Application Reference: 2025/0966

Site Address: 48 Bow Street, Cudworth, Barnsley, S72 8JW

Introduction: This application seeks full planning permission for a Two storey side extension to dwelling.

Title: PROPOSED FLOOR PLANS

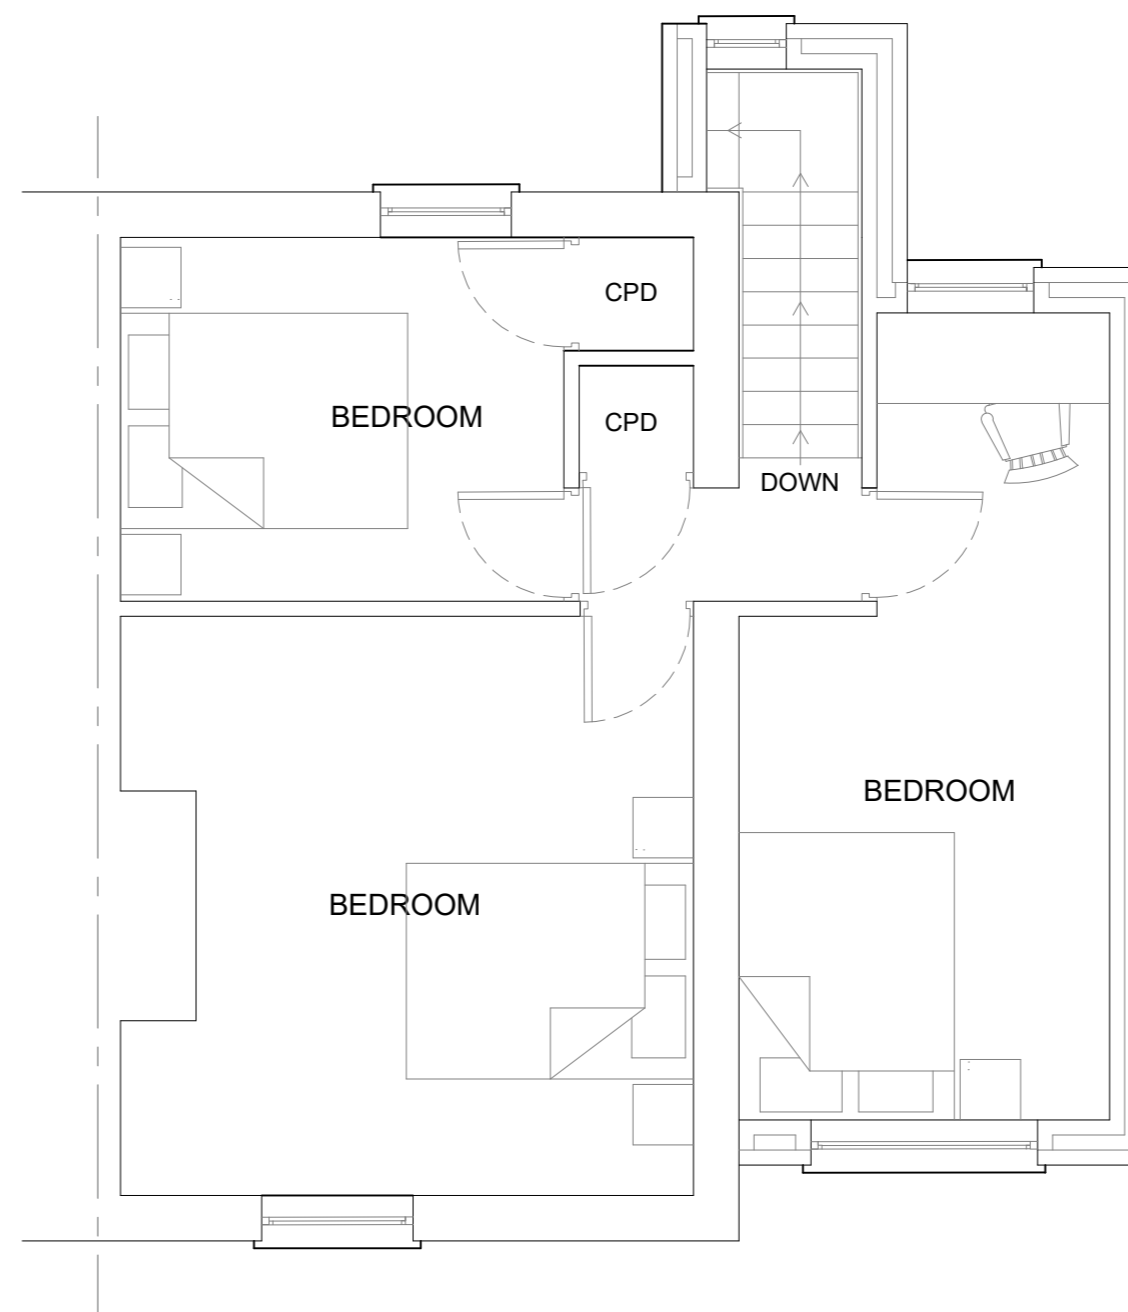
The proposal has been reduced in scale to meet the requirement of SPD House extensions and other domestic extensions, which restricts the size of side extensions to two thirds of the width of the original dwelling. With an approximate width of 2.75m and an original house width of 4.24m, the proposal meets this requirement.

For the application dwelling, the proposal includes a single, and modest sized rear bedroom window within the first floor of the extension. Usually a distance of 10m is required between such a window

Title: PROPOSED FLOOR PLANS AND ELEVATIONS

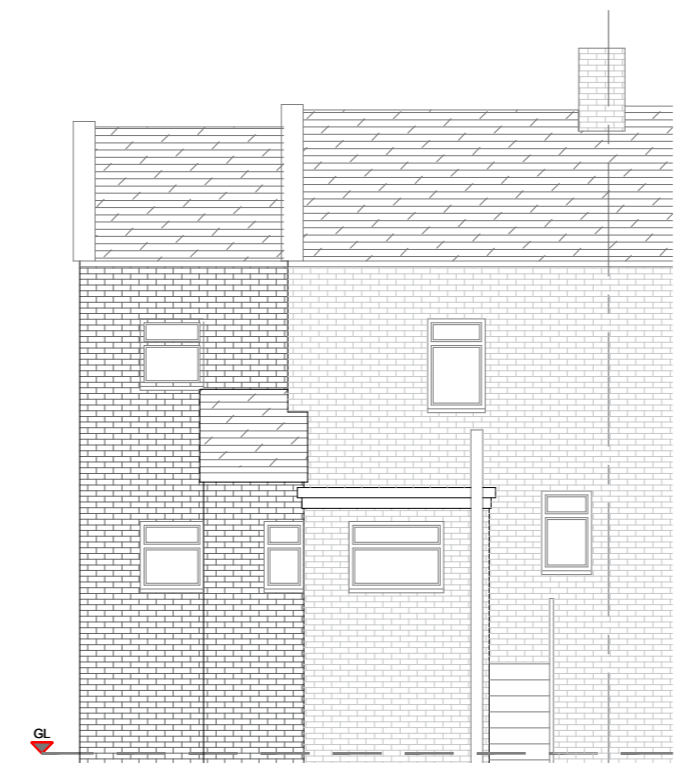
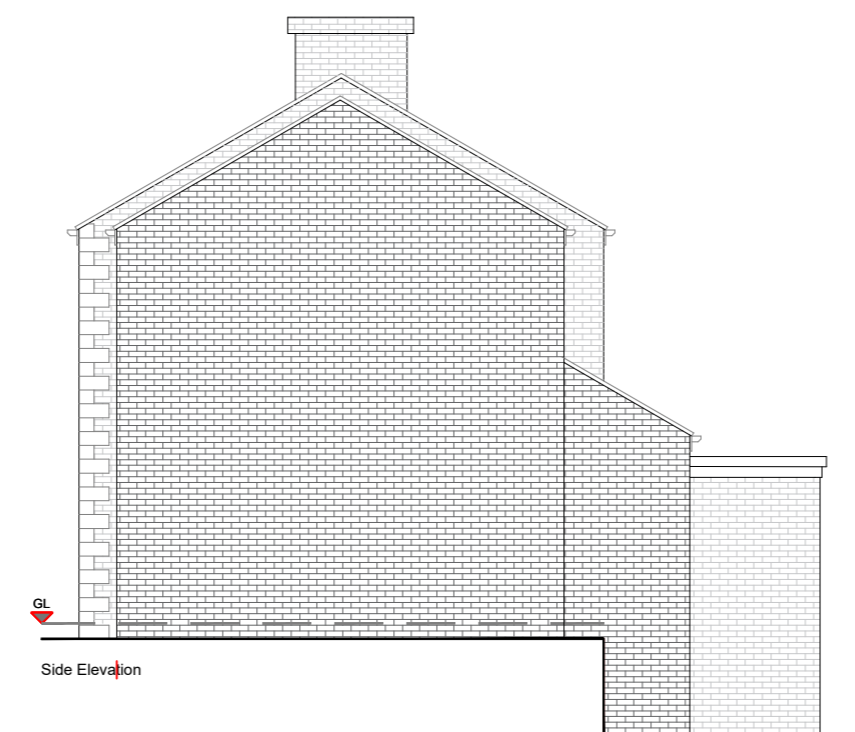
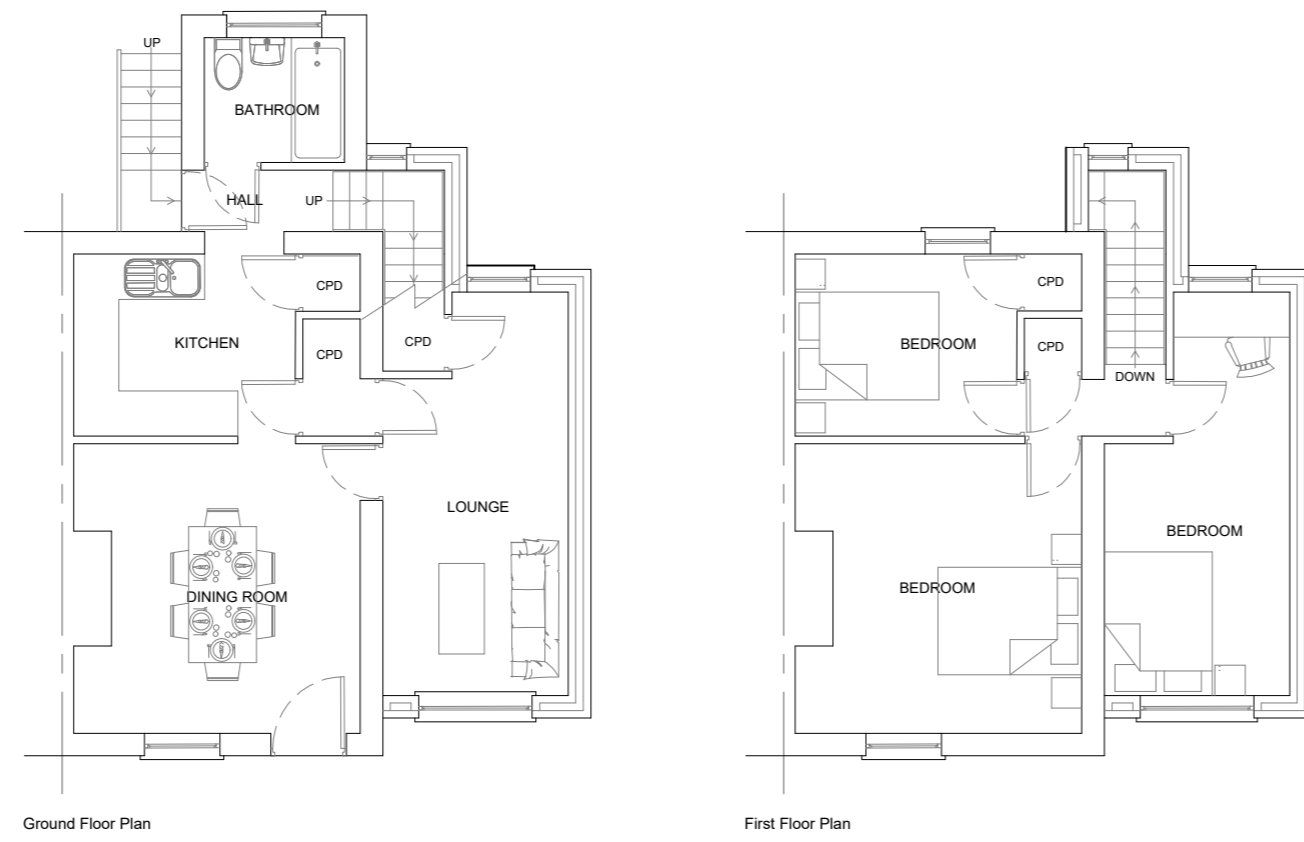
The SPD requirements also requires extensions to feature a step down of their roof, and a setback from the front elevation to show subordination to the original dwelling. The proposal has again been amended to meet both of these requirements.

and the rear boundary treatment, 12m to a blank elevation of a neighbouring dwelling, and 21m between habitable room windows. Due to the unusual layout of the applicant's dwelling, there is only around 4.5m to the rear (side) boundary, about 16m to the rear of a dwelling on Barnsley Road, due to the angles of the dwelling, it would not appear that any windows would directly overlook each other.

As the window is set back approximately 0.6m from the existing rear elevation, and existing rear windows, the proposed window would have less of an impact than the existing windows. However, the window would overlook the rear gardens, of dwellings on Barnsley Road, and this may be considered as a moderate impact on neighbouring amenity. Mitigation would arise from the fact of the already noted mutual overlooking of the dwellings of both streets.

- The original proposal was deemed too large and featured no step down of the roof or set back. The amended plans addressed this issue.
